Development Application and Planning Proposal Review NSW Planning Portal Concurrence and Referral

Address	Land Title
4 - 4A Flinders Street, North Wollongong	Lot 432 DP 1006372

Environmental Impact Statement (EIS) for Mixed Use Development - Flinders St, North Wollongong. 270 apartments including 15% of GFA for affordable apartments, 150 hotel rooms and commercial GFA in a 38-storey building.

1 GROUND FLOOR
1 : 500

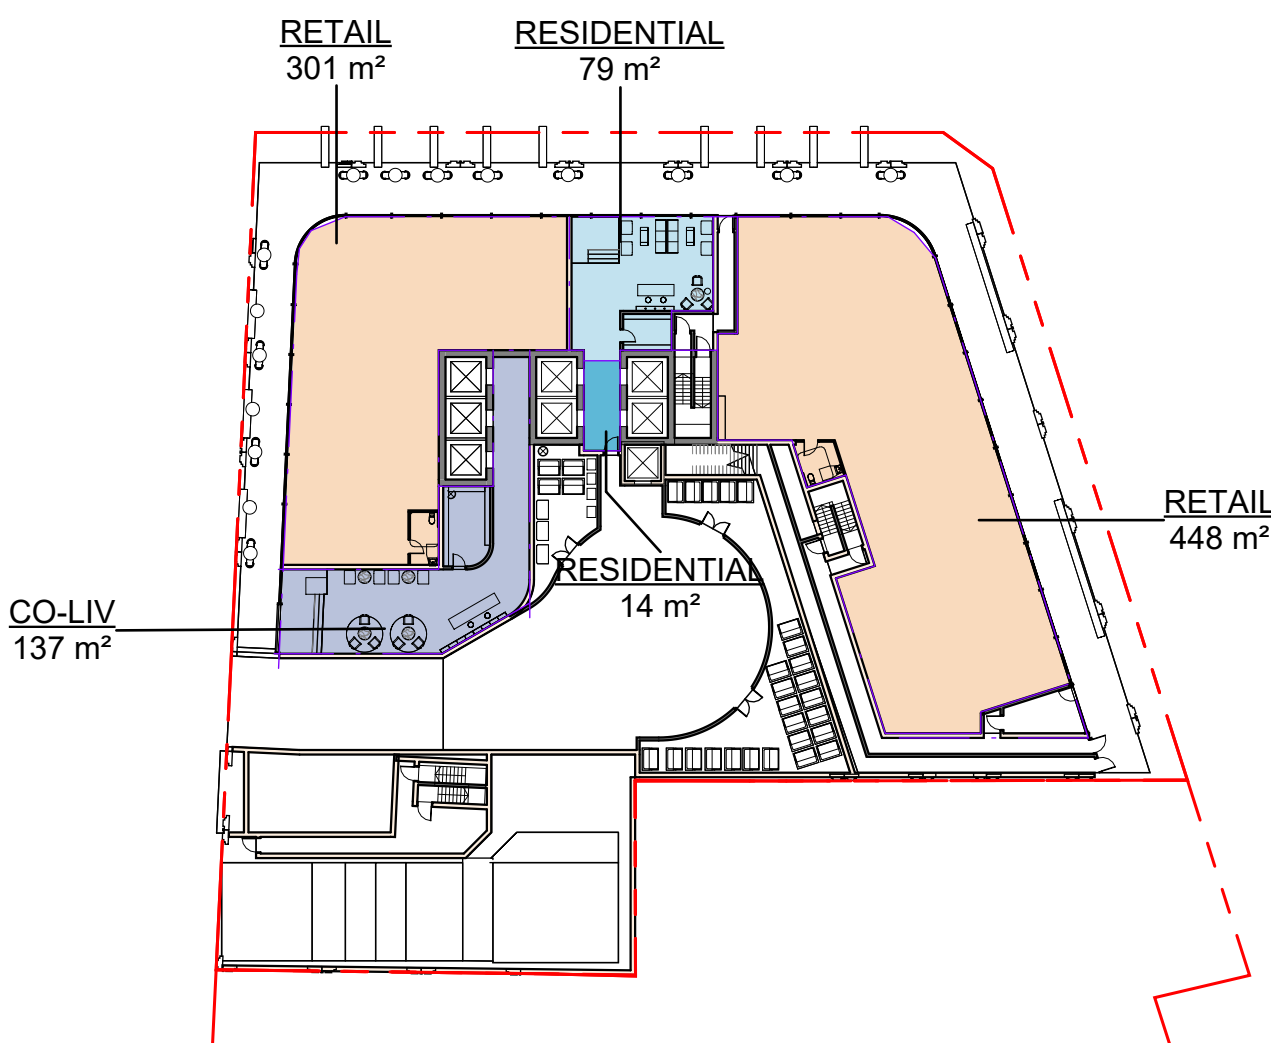
- Any required distribution substation/s will need to be located within the property (in a suitable and accessible location) and be protected (including any associated cabling not located within a public road / reserve) with an appropriate form of property tenure as detailed in the attached copy of Endeavour Energy's 'Land Interest Guidelines for Network Connection'.

Generally it is the Level 3 Accredited Service Provider's (ASP) responsibility (engaged by the developer) to make sure substation location and design complies with Endeavour Energy's standards the suitability of access, safety clearances, fire ratings, flooding etc. If the substation does not comply with Endeavour Energy's standards, the applicant must request a dispensation.

- **Electricity:** Two (2) 1000kva chamber stations are required to cater the full electrification of the proposed mixed-use building. These substations are located on the ground level.

The below copy of the GA Plan - Ground Floor shows provision for an indoor substation to the Stafford Street road frontage.
